Your Ref :
Our Ref : FG/120/17/NMA

Section 96A of the Town & Country Planning Act 1990 (as amended)
Town and Country Planning (Development Management Procedure) (England) Order 2015 (as amended) - Article 10

Application for a non- material amendment following the grant of FG/194/15/HH to replace entire roof covering at time of proposed works including replacment of all fascias, soffits, guttering, ridge verges & valleys.
9 Greenways Crescent, Ferring, ,

9 Greenways Crescent
Ferring, BN12 5EF
Proposed Elevations
Scale 1:100 @ A3

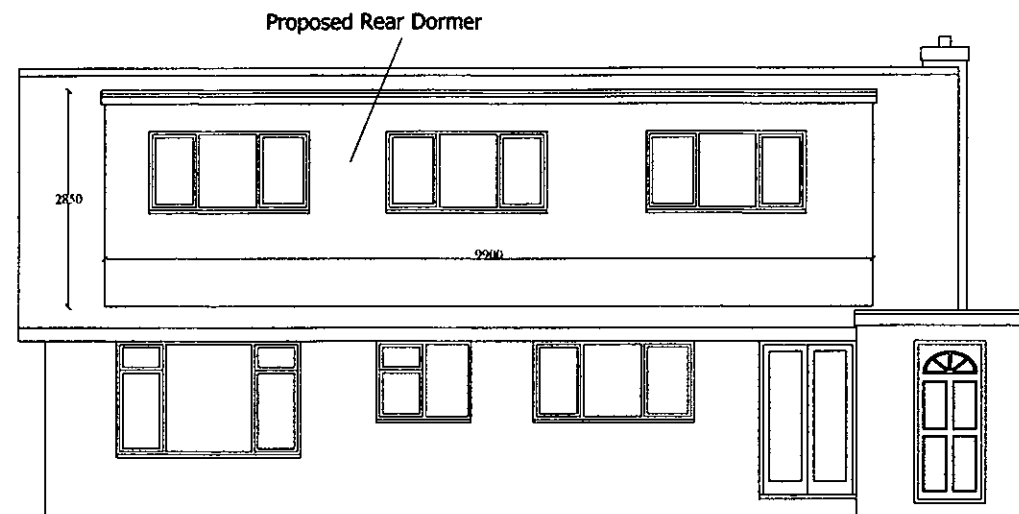
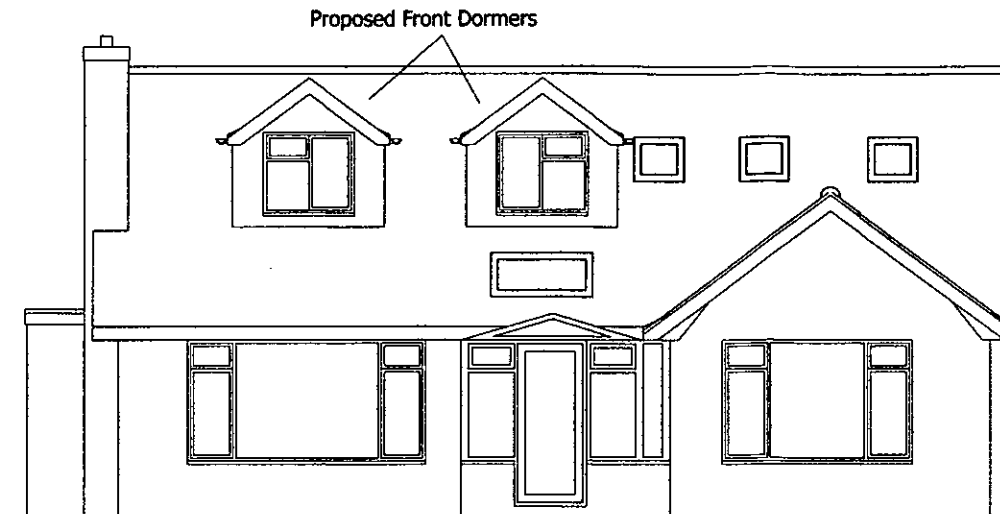
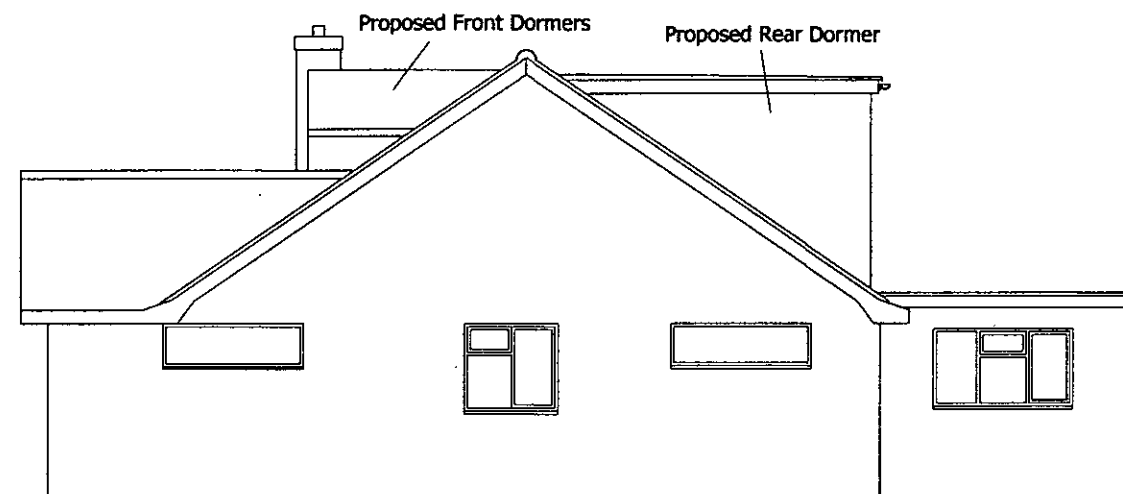
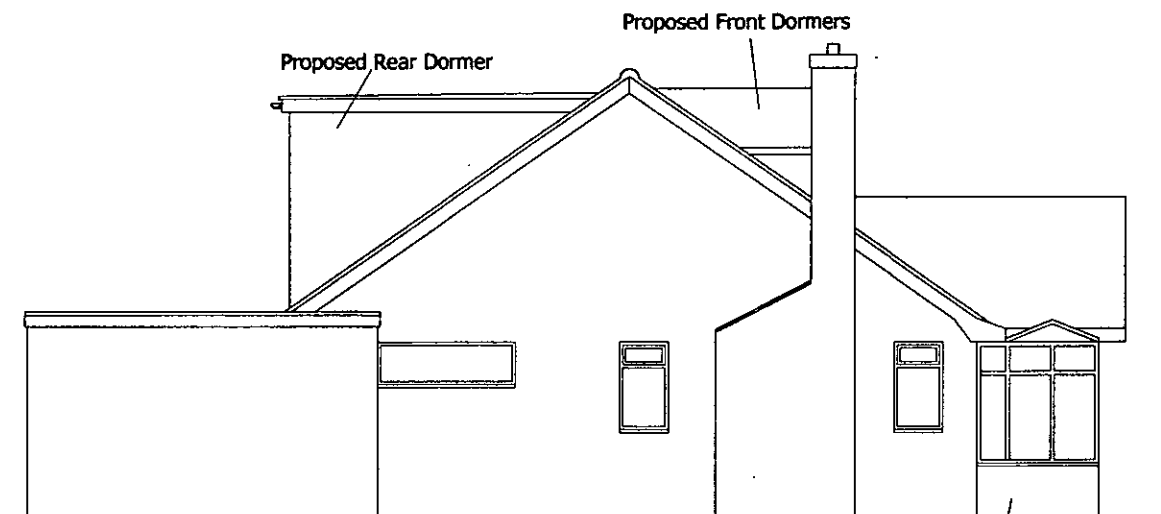
I refer to your recent application for a Non Material Minor Amendment. From the information submitted I am able to accept the addition of roof lights to the primary elevation as indicated on drawing 'Proposed elevations - Rev C' as a non-material amendment.

However, the replacement of the existing roof material with 'Smooth Grey - interlocking concrete tiles' and the replacement of the existing soffits and fascias with white uPVC and existing guttering with black uPVC cannot be accepted as a Non-Material Amendment to FG/194/15/HH.

As the materials proposed were secured via condition 3 of planning approval FG/194/15/HH it is necessary for this to be regularised through the variation of condition rather than via a non-material amendment application.

Accordingly drawing 'Proposed Elevations - Rev C' becomes the approved plan for planning application FG/194/15/HH only insofar as it relates to the addition of roof lights to the primary elevation of the dwelling.
